Submission No.			27	
Organisation Name or Name of Submitter			Brendan Heneghan (88 Parkmore Drive)	
Item No.	Section Ref.	Page No.	Observation Statement	TII Response
Ref: Metro planning application no 314724, 25 November 2022				
1	Letter	1	<p>A lot of people get off at Charlemont no doubt headed for the metro. They are holding up the tram bound for Bray crossing the railway line to get to the stairs. And there's people coming up the stairs slowing them down. Someone has got the wheels of his case stuck in the track.</p> <p>The lady announces a slight delay. I'm told that there's persistent problems with turning the Luas that finish at Charlemont and because all the passengers have to get out, they are stopped longer at the station too. However we move off a minute later.</p>	<p>The Luas stations are designed as a shared space between pedestrians and trams, hence the designated pedestrian crossing between the Charlemont Stop Luas platforms. The interaction between pedestrians and trams will be managed the same as for any other Luas stop.</p> <p>The stairs referred to have been sized to accommodate the combined predicted passenger flows for Luas to Metro, and Metro to Luas. The lift

CHARLEMONT STATION

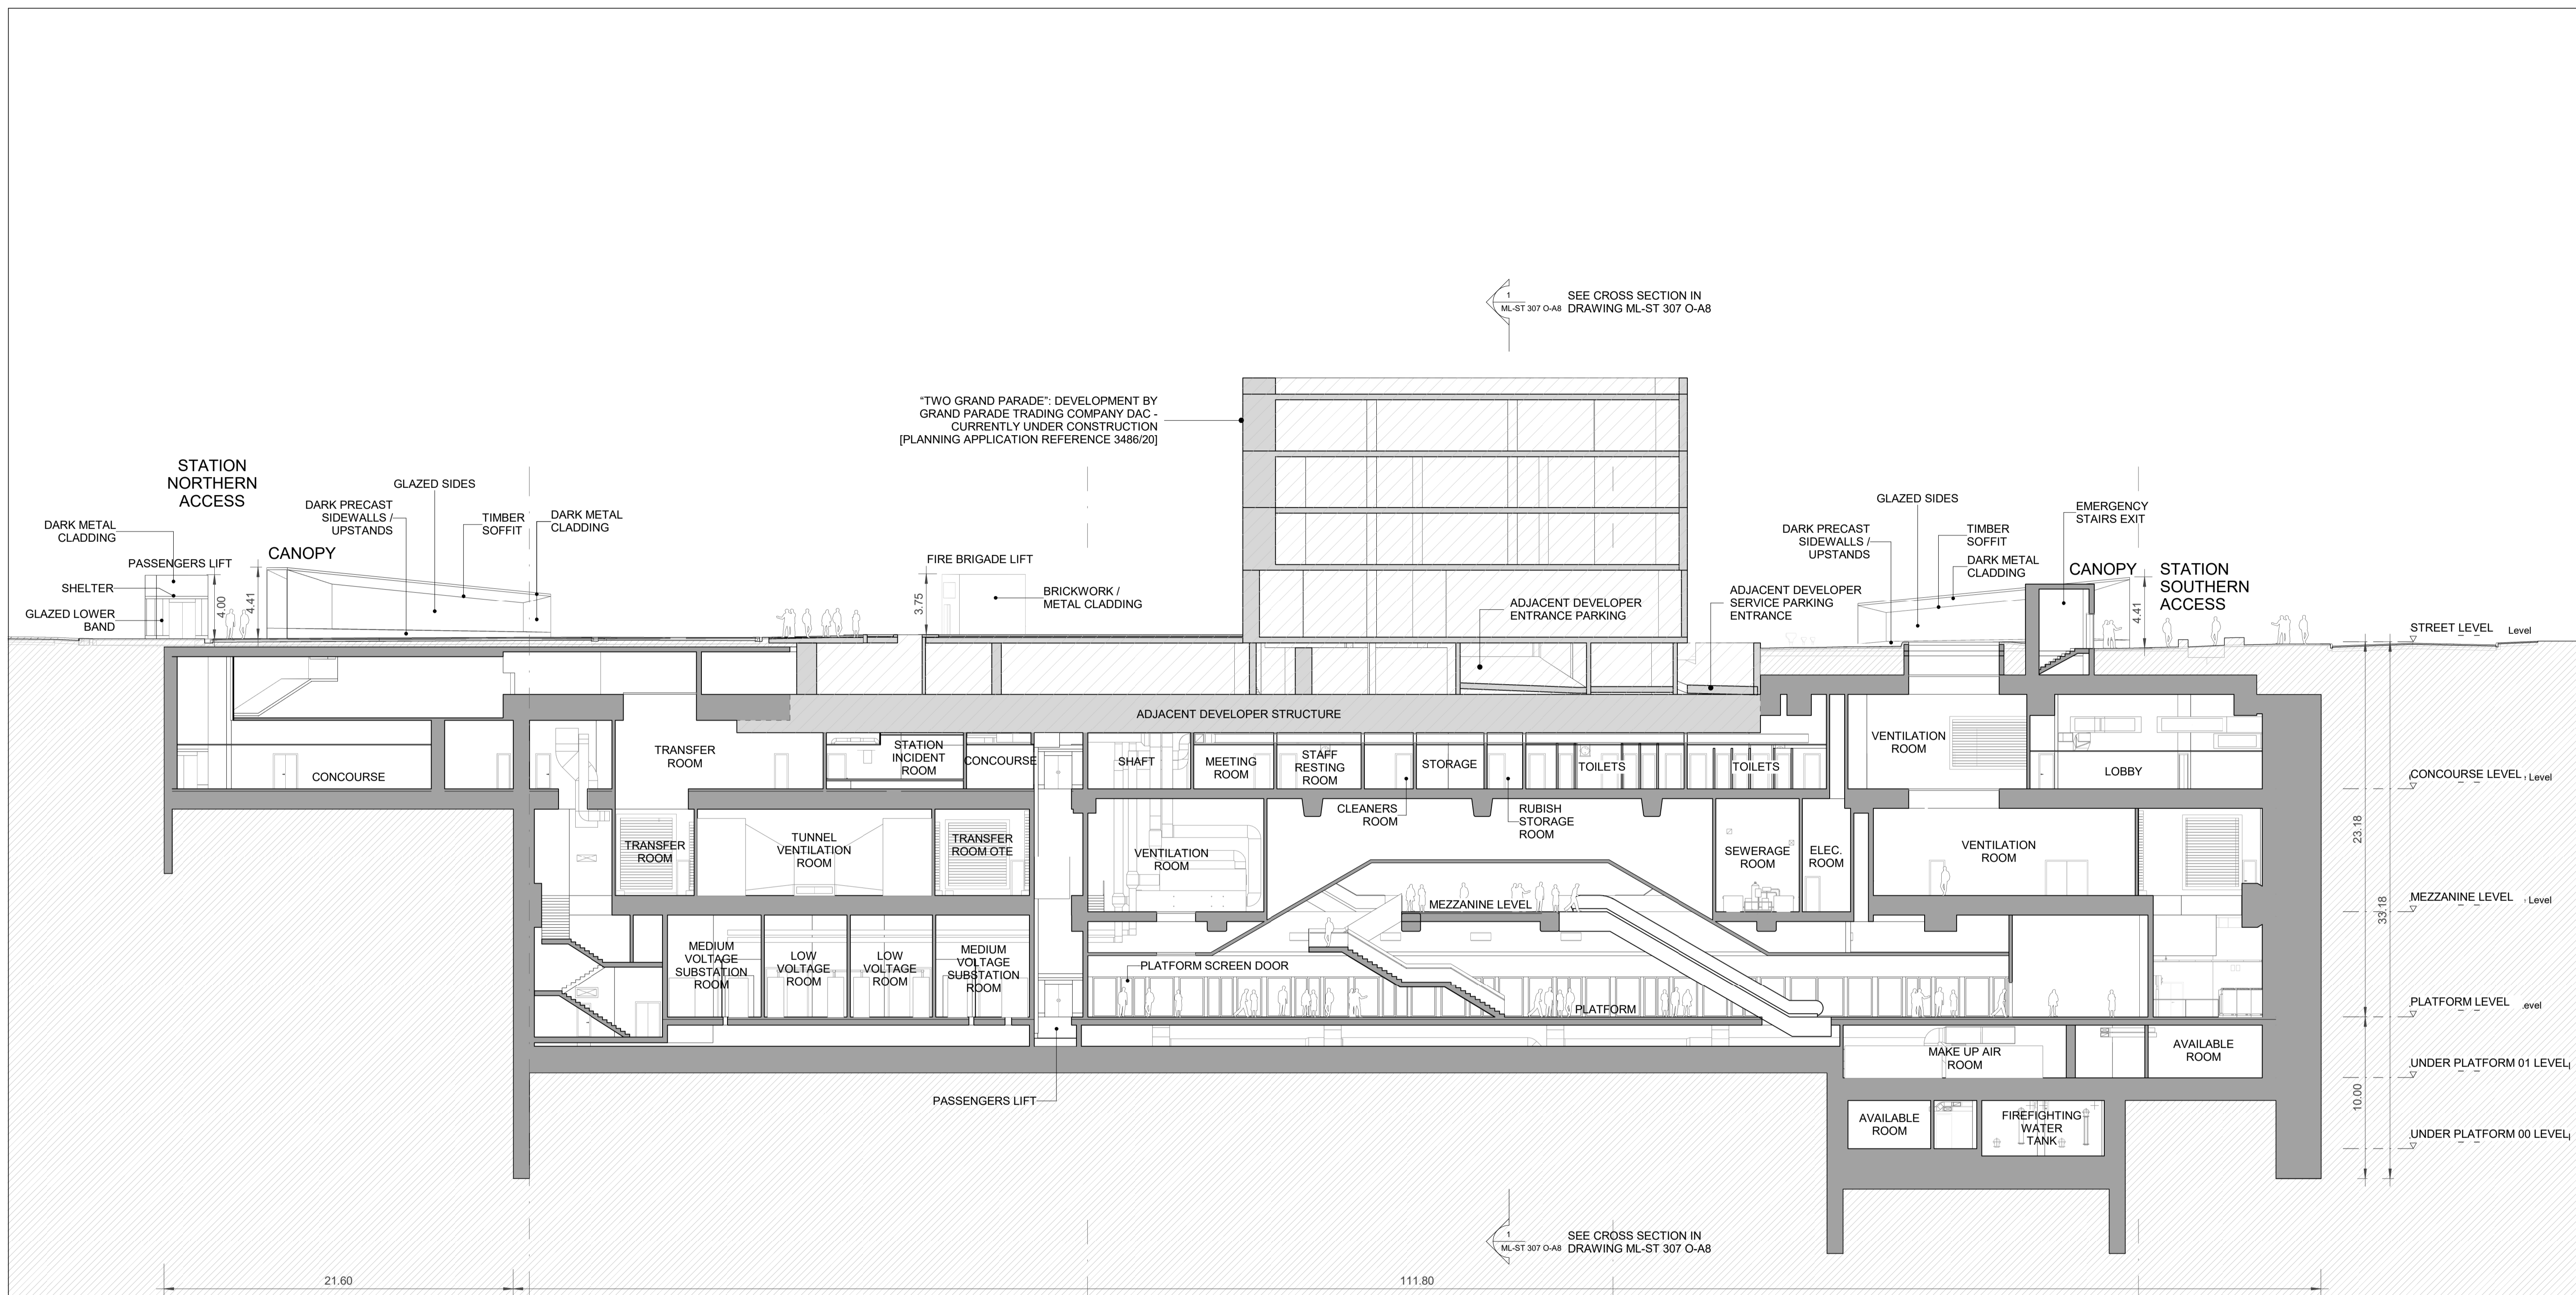
2	Letter	2	<p>On our previous holiday to Lanzarote, we made the mistake of getting off the Luas at Charlemont and transferring to the metro at that point. The metro had just opened. We had massive problems getting the cases down the stairs. Some guy coming up the stairs barged into the missus, even though the signs all say keep to the left. I ended up having to go back up to fetch her case. Not great to have to leave it there as it was a bit of an obstruction. There was a big queue for the lift. I can't get why they didn't put in escalators. Any why didn't they have the metro directly under the Luas with a bank of lifts and escalators. We have to find another way to get to the airport for the pre-Christmas trip.</p> <p>And the return was even worse. Lugging the cases full of the souvenirs for the grandkids up seven flights. That stairs is a nightmare. And when we reached the platform everyone was blocking the platform at the top of the stairs. Took all the benefit out of the holiday. It's like that awful transfer at 168th St Manhattan when you get off the A train from JFK and want to get the 1 to the Bronx.</p>	<p>As noted by response (1) above, the stairs should not be used by passengers carrying luggage of a size not suitable for stairs, and the stairs and lift have been sized for predicted passenger flows, as indicated in Chapter 6 (MetroLink Operations and Maintenance, section 6.4.1), with a lift capacity of 10 passengers.</p> <p>Chapter 6 (MetroLink Operations and Maintenance) indicates that the operation strategy of the proposed Project is driven by the forecasted passenger demand. As such, the peak passenger demand profiles for each station have informed the layout and sizing of platforms and stations to ensure safe and comfortable movements of all users. In recognition of the higher footfall anticipated at this station, two stations entrances are proposed. Additionally, three escalators will be provided at the northern entrance between the station and concourse levels, reflecting the higher footfall predicted with the connection to the Luas line. As presented in Appendix A9.2-B Traffic and Transport Assessment- Charlemont Station, pedestrian modelling of the station indicates that the design has sufficient capacity to accommodate the pedestrian demand generated at the Charlemont MetroLink station.</p> <p>Within the constraints of the site it is not possible to fit escalators in linking ground level to the Luas, and nor would it be feasible to economically place a station beneath the existing Luas that met the MetroLink operational requirements and architectural vision for the Project. It is also highly likely the demolition of buildings would be required around the Luas if such an option was developed and it would not be possible to provide the quality of station entrances that has been achieved for the proposed Charlemont Station.</p>
